Project Name: * Widening of I-440 from Wade Avenue to Walnut Street

April 23, 2021

Subject: **Request for Modification to the Regional General Permit Number 198200031, Section 401 Water Quality Certification, and Neuse Buffer Authorization for U-2719 – Improve Existing I-440 Beltline, from south of SR 1313 (Walnut Street) to north of SR 1728 (Wade Avenue). Debit WBS 35869.1.2**

PROJECT REFERENCE NO.	SHEET NO.
U-2719	14
RW SHEET NO.	
ROADWAY DESIGN ENGINEER	HYDRAULICS ENGINEER
DOCUMENT NOT CONSIDERED FINAL UNLESS ALL SIGNATURES COMPLETED	
Gradiant, PLLC 127 W. Chatham St Cary, NC 27511 N.C.B.E.L.S. License Number: P-1875

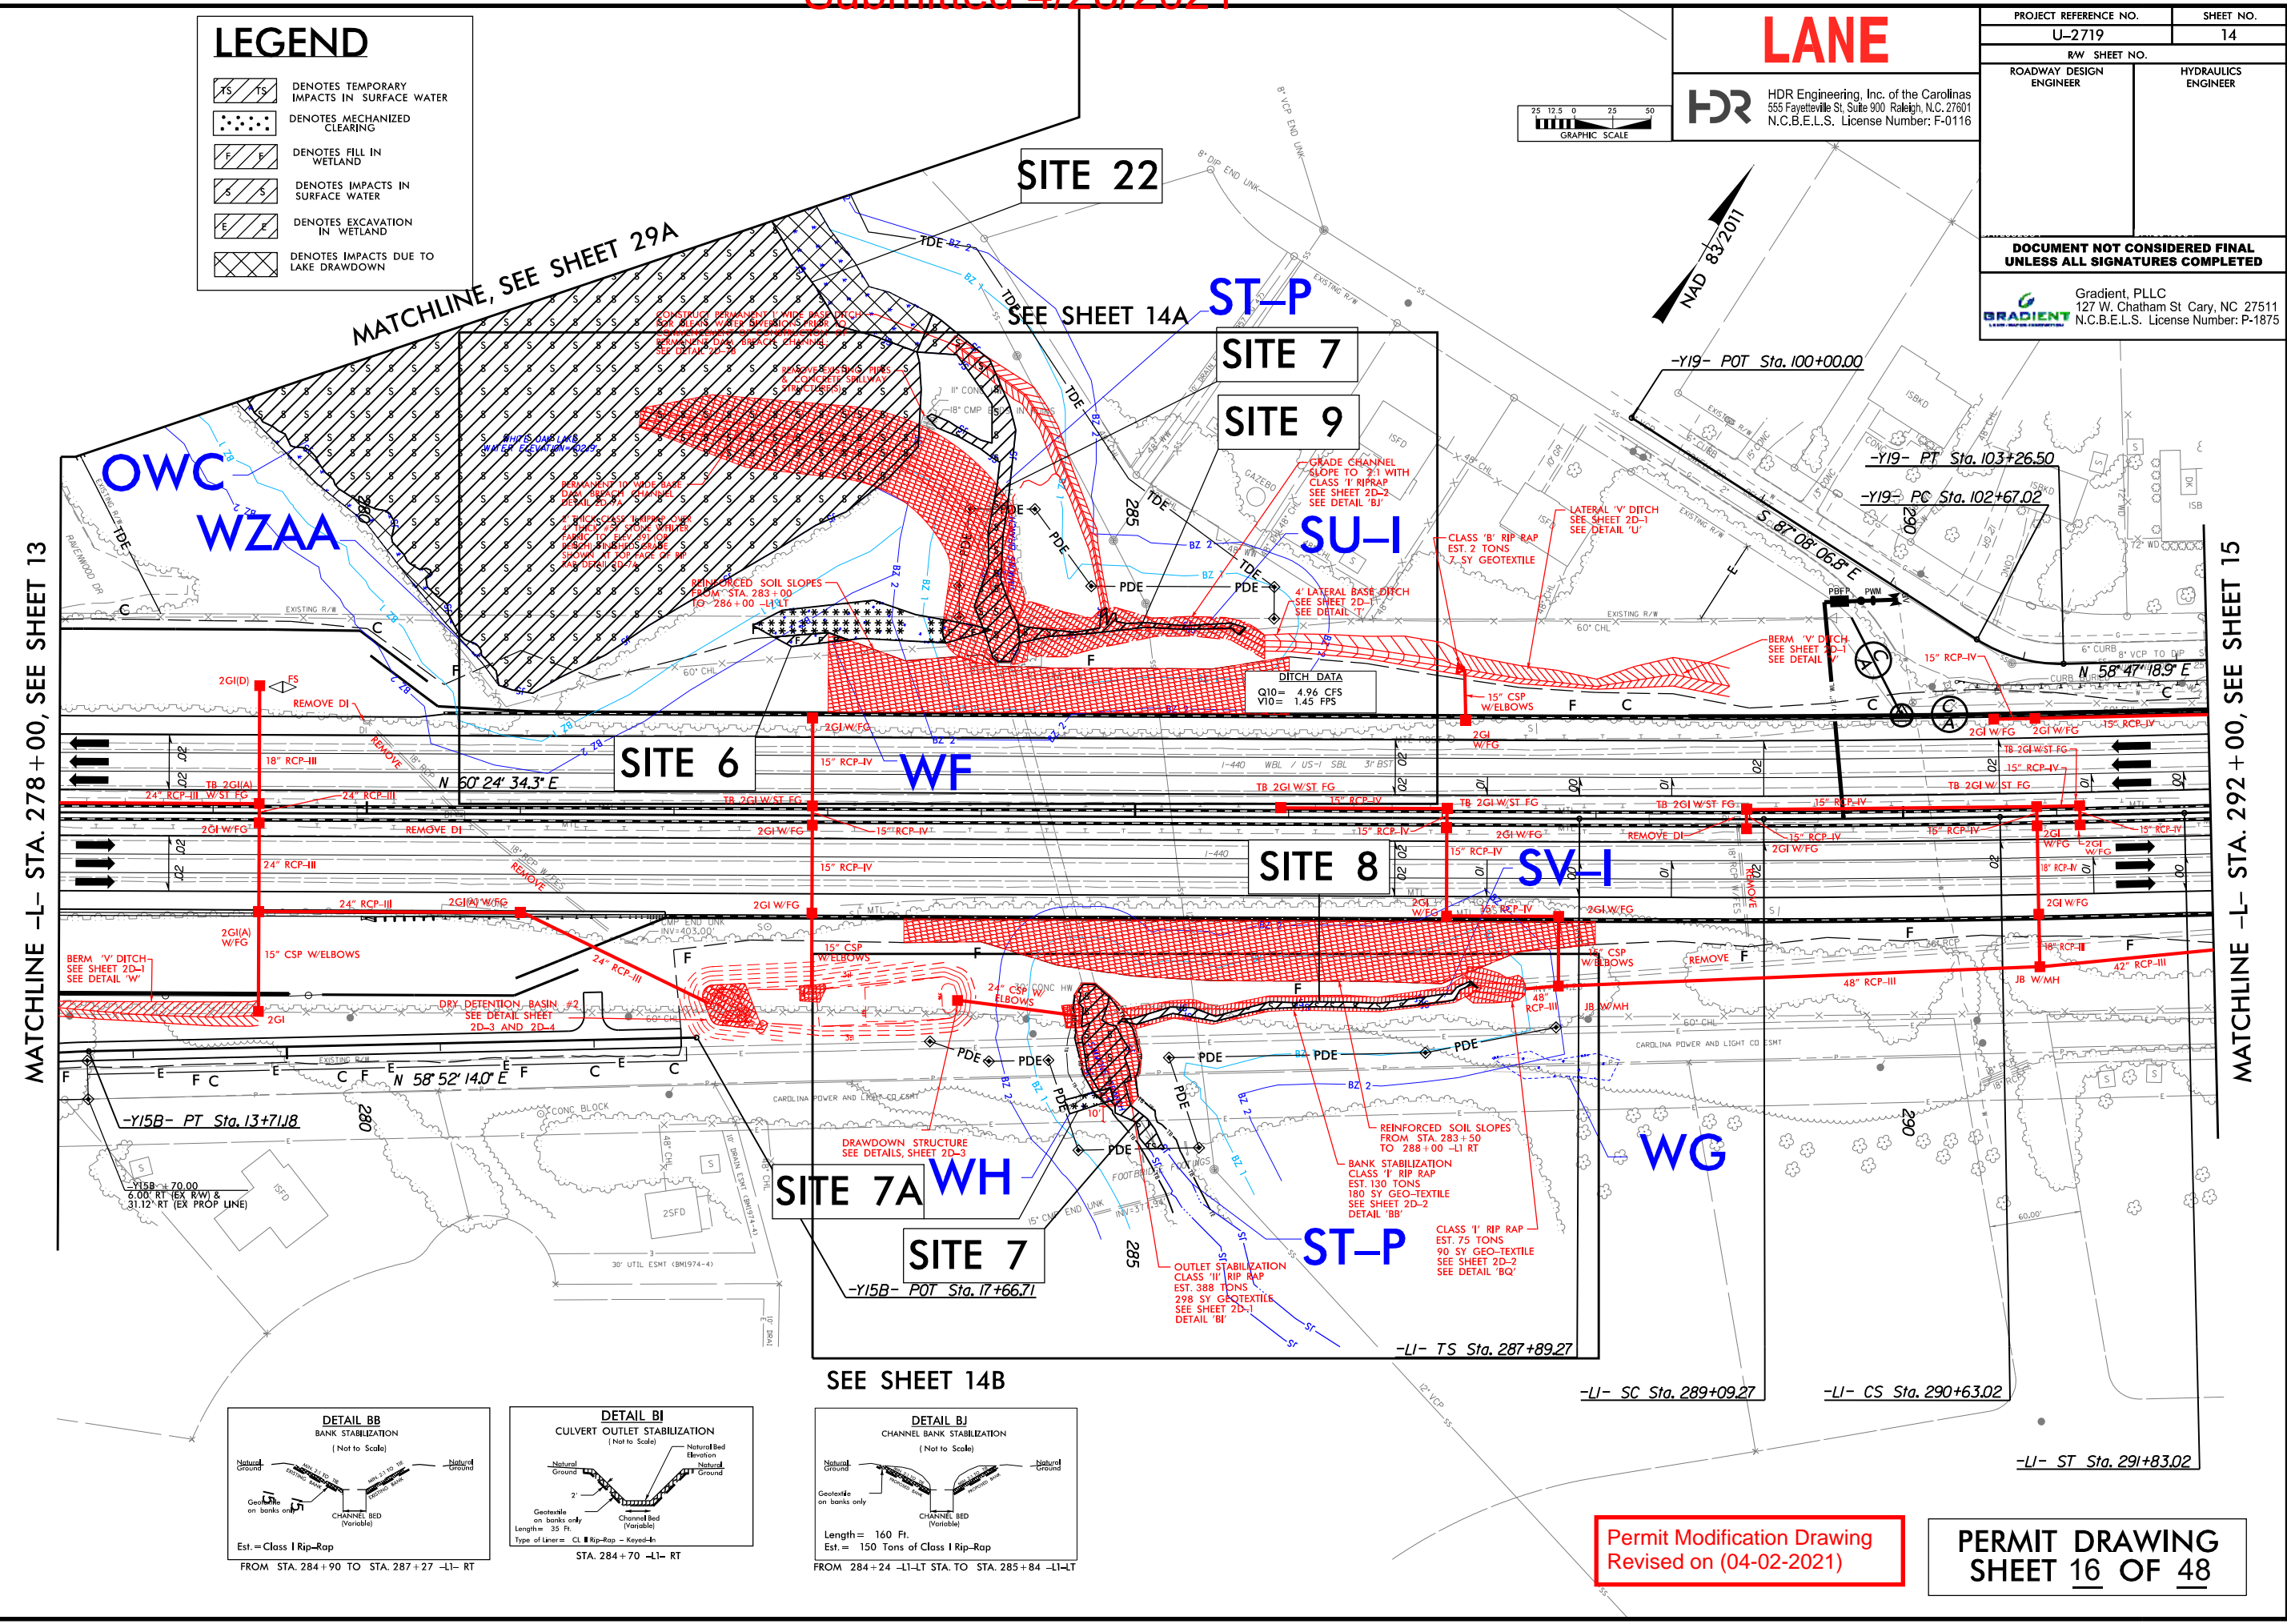
Site 6 (Sheet 14) – Site 6 has an increase of 0.04 ac of wetland impacts due to mechanized clearing. This impact is a result of the additional rock stabilization needed along the roadway fill slope and access for breaching the dam. The impact at Site 6 is now 0.01 ac of permanent fill and 0.05 ac of mechanized clearing.

Site 7 (Sheet 14) – Site 7 has an increase in permanent stream impacts and buffer impacts due in part to the new delineation as well as the extended impacts related to the dam breach. The increase in permanent stream impacts is due to relocation and stabilization of the stream once the dam is breached. The new stream impact for Site 7 is 298 lf of permanent stream impact from the dam breach to the inlet, 97 lf of outlet protection, and 22 lf of temporary stream impact. This is an increase in permanent stream impact by 360 lf and a reduction of 28 lf of temporary impact for Site 7.

Buffer Site 7 (Sheet 14) – Site 7 buffers have changed as they will now be impacted by the White Oak Lake dam breach and access requirements. The total impact in Zone 1 is 14,399 sq ft and Zone 2 is 6,548 sq ft for Site 7. This is an increase in Zone 1 impact by 12,939 sq ft and 5,677 sq feet in Zone 2. Site 7 buffer impacts on the outlet side were reviewed and it was determined that those have been previously cleared and are no longer illustrated as an impact.

Site 7A (Sheet 14/14B) – Site 7A has been added due to the need for extended outlet stabilization in Simmons Branch and access. The wetland will have a small amount of fill (<0.01 ac) due to the rock stabilization and the remaining portion (<0.01 ac) is shown as mechanized clearing. The wetland is within the maintained utility easement and has already been cleared through ongoing utility maintenance.

Site 9 (Sheet 14/14A) – Site 9 was slightly different based on the old JD files in the original permit application. This channel has been updated with the new JD files as described above which extends the channel approximately 85 lf. This reach was also previously impacted due to bank stabilization; however, with the changes in design at this location it was determined that the entire channel would require rock armoring to stabilize the area. This is now shown as a permanent fill/stabilization impact on the summary impact table. There is an 85 lf increase in impact due to the new JD file. The new impact is 147 lf which is shown as permanent fill/stabilization impact.

Buffer Site 9 (Sheet 14/14A) – Site 9 buffers have also changed as a result of the new JD file. Site 9 buffer impacts have increased in Zone 1 by 2,708 sq ft to 6,639 sq ft. Zone 2 buffers have increased by 1,392 to 2,738 sq ft. No additional buffer mitigation is proposed for the additional buffers associated with the new JD file, as redesign and impacts are linked to the dam breach impacts which were previously considered non-mitigable by NCDWR.

Site 10 and Site 11 (Sheet 14/14A) – Previous wetland Sites 10 (WJ) and 11 (WI) have been removed due to the most recent JD files discussed above. The area that was previously illustrated as wetland is part of stream SU-I in the revised delineation. This results in a reduction in wetland impact by <0.01 ac of excavation and <0.01 ac of mechanized clearing for Site 10 and <0.01 ac of excavation and <0.01 ac of mechanized clearing for Site 11.

Buffer Site 10 (Sheet 14/14A) – Previously there were no impacts illustrated with the buffers around White Oak Lake due to the City of Raleigh project. The buffer impacts illustrated at Site 10 are associated with construction and access for the dam breach at White Oak Lake. This results in 10,337 sq feet of Zone 1 impacts and 4,597 sq ft of Zone 2 impacts.

Site 22 (Sheet 14/14A/29A) – Site 22 was added to illustrate the open water impacts associated with breaching the dam of White Oak Lake. The open water impact associated with the breach is 5.10 ac. This site also includes impacts to the fringe wetlands around the lake due to the drawdown of the lake. This area has been hatched on the attached plan sheets and the 2.65 ac of wetland fringe has been noted at the bottom of the summary impact table since it does not match any of the wetland impact types illustrated on the summary table.
